**CONSULTATION UNDER THE TOWN AND COUNTRY PLANNING
(DEVELOPMENT MANAGEMENT PROCEDURE ENGLAND) ORDER 2015**

Planning Application Reference:	WA/106/20/DOC
Proposal:	Approval of details reserved by condition imposed under ref WA/22/15/OUT relating to Condition Nos 6 - materials & finishes, 10 - hard & soft landscaping, 11(a) - protection of retained trees, 12 - surface water drainage, 14 - maintenance & managements of SuDs, 15 - foul drainage and 20(d) - forecourt layout, drainage, position & intensity of lighting fitments.
Location:	GTR Ltd Arundel Road Fontwell Arundel BN18 0SB
Date:	17 February 2021

Portsmouth Water have reviewed the discharge of conditions 12, 14, and 15 relating to outline planning permission WA/22/15/OUT.

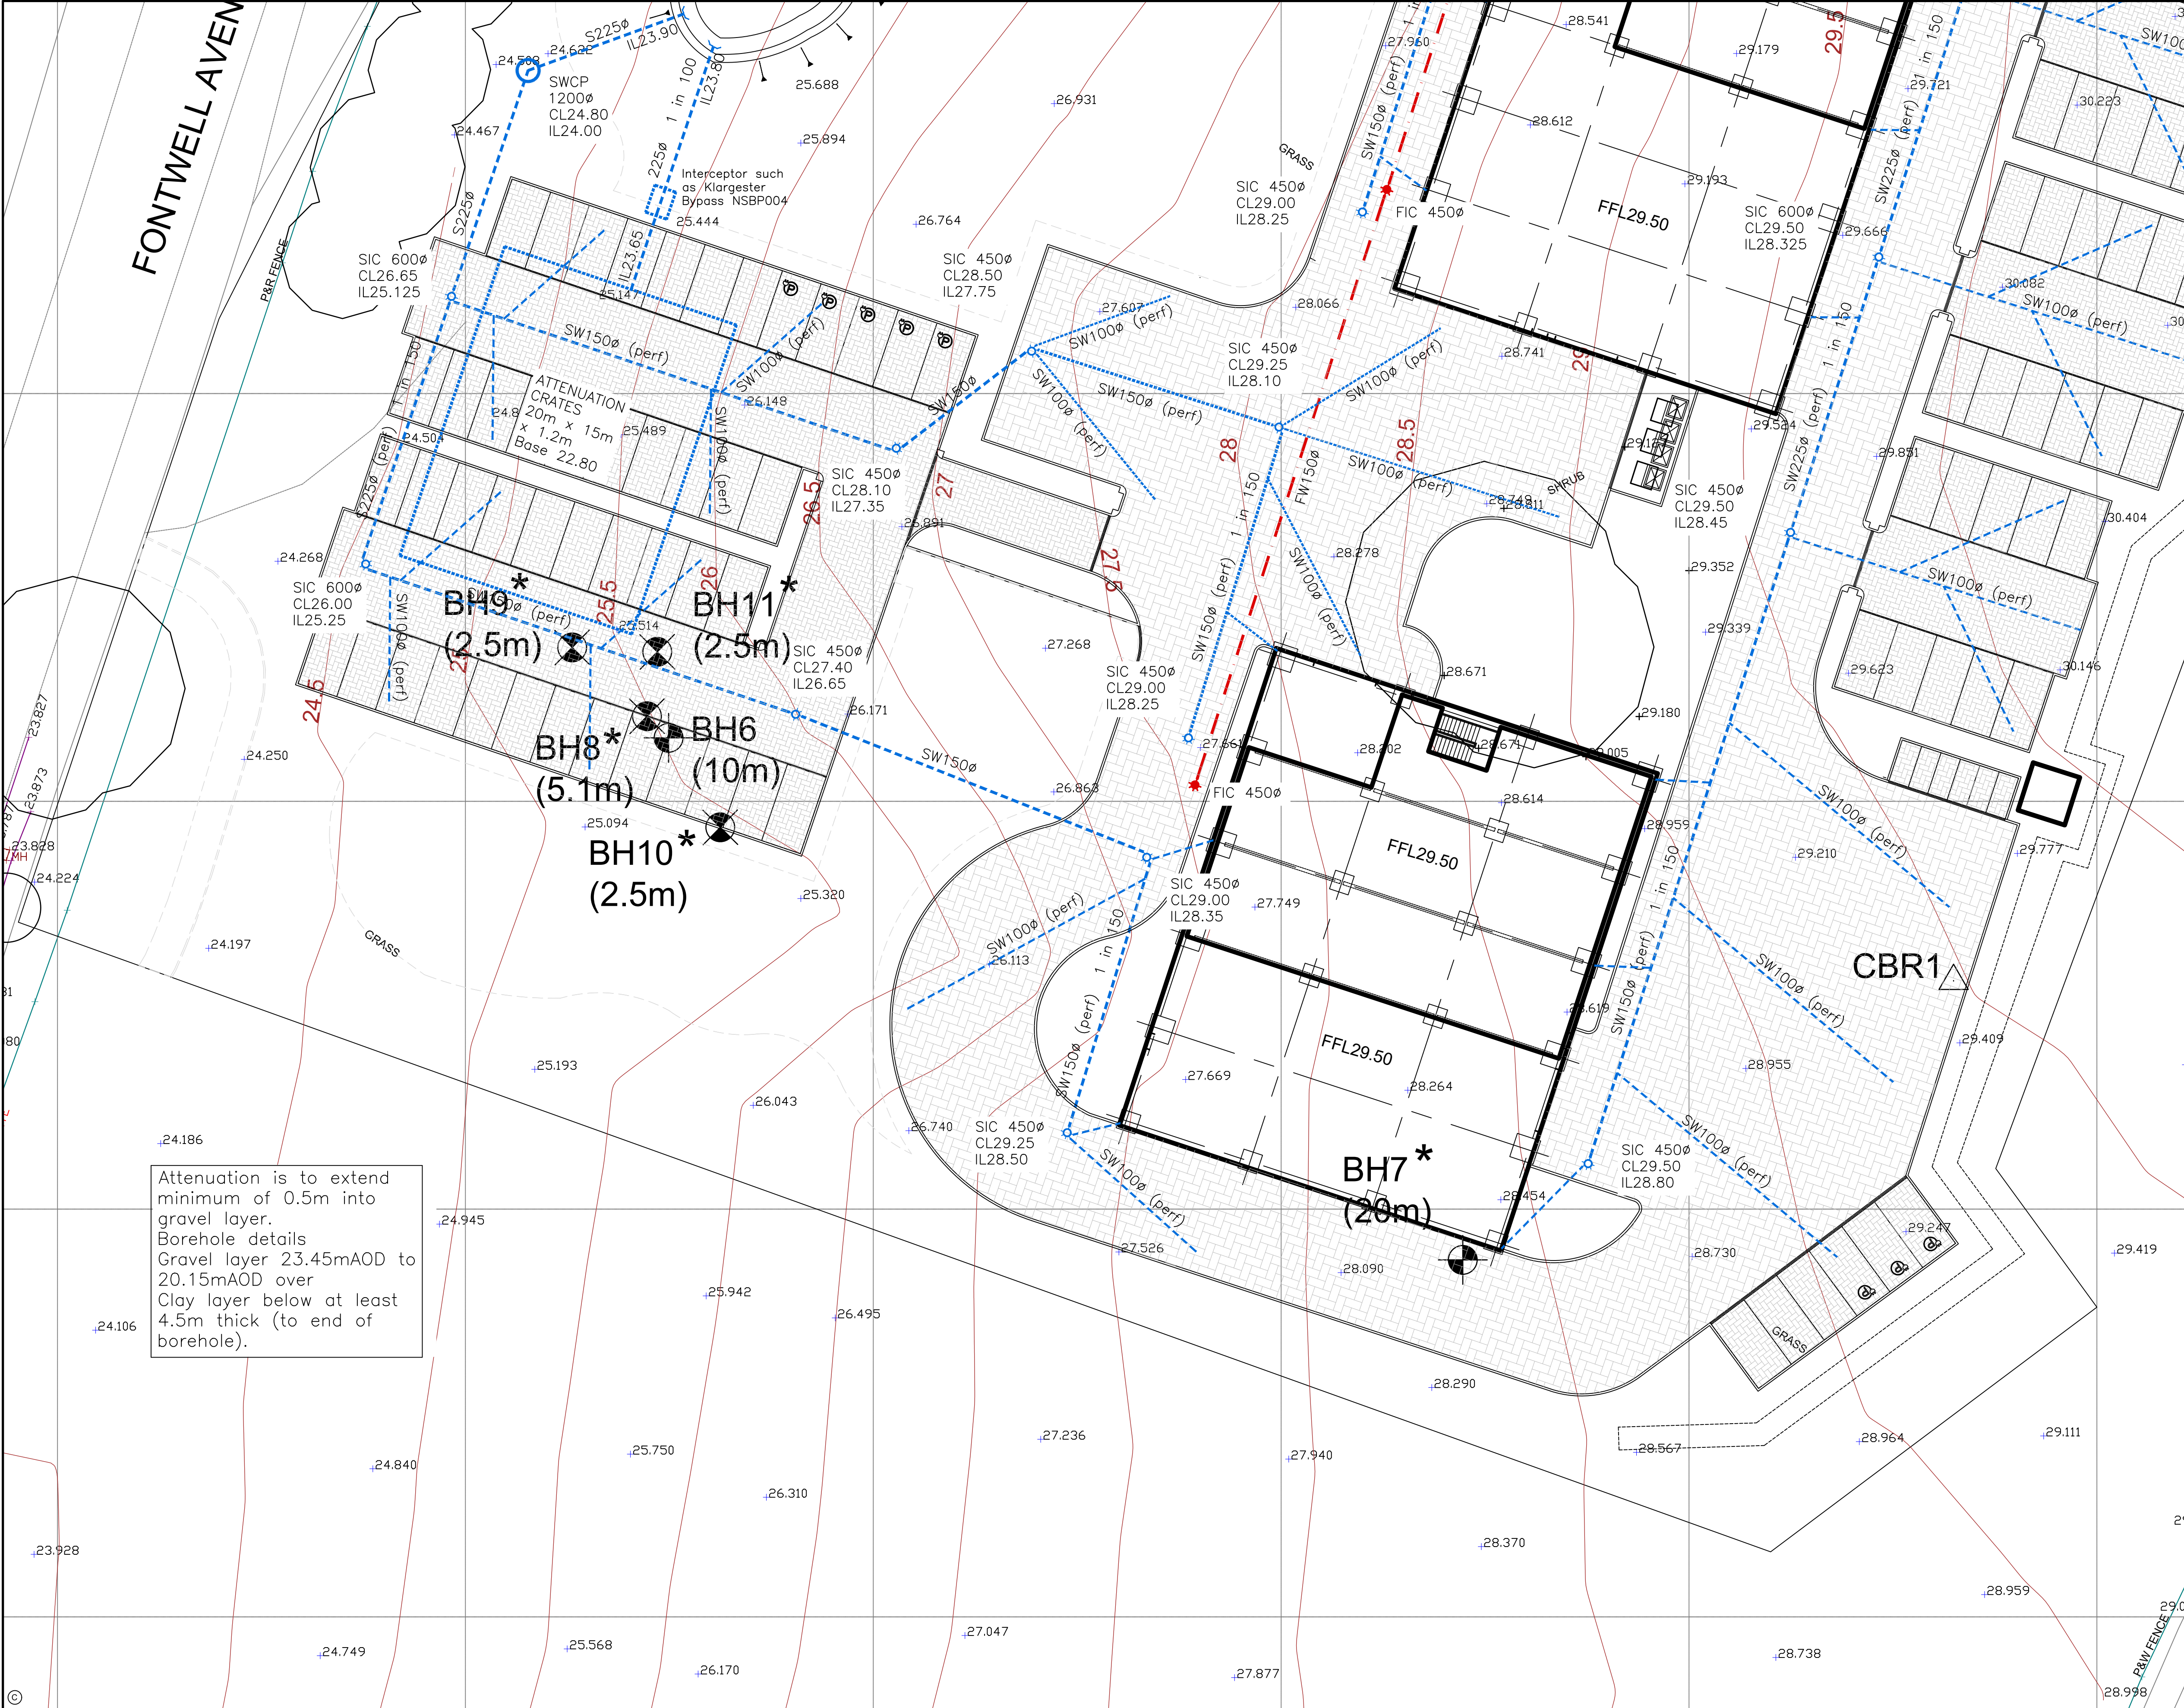
We have reviewed the Drainage Layout Drawing Sheets 1 and 2 (ref: 15104/20 and 15104/21). There is insufficient information to allow us to be satisfied with the discharge of Condition 12. The drawings outline the drainage proposal for the industrial area, this comprises permeable paving and surface water sewer connections to a drainage basin. There is one bypass interceptor, on the drawing it appears the interceptor is between the car parking area in the south and the drainage basin. On the contrary, the drainage engineer email states the bypass interceptor is on the outfall between the drainage basin and a soakaway. It is unclear the location and purpose of this interceptor and this should be detailed in a drainage strategy for the area. In addition, the discharge point of the basin is unclear as there is no soakaway on the drawings provided.

No detailed drainage strategy for this industrial area has been submitted. This detailed information is required to ensure the water quality risks to groundwater are adequately addressed and where required mitigated. Portsmouth Water require a detailed drainage strategy for the industrial area detailing the type of drainage basin (attenuation or infiltration), details of the SW connections, SW outfalls (discharge points) and the level of water quality treatment is suitable for the land use (B1 (b)/(c)) with reference to the CIRIA SuDS Manual.
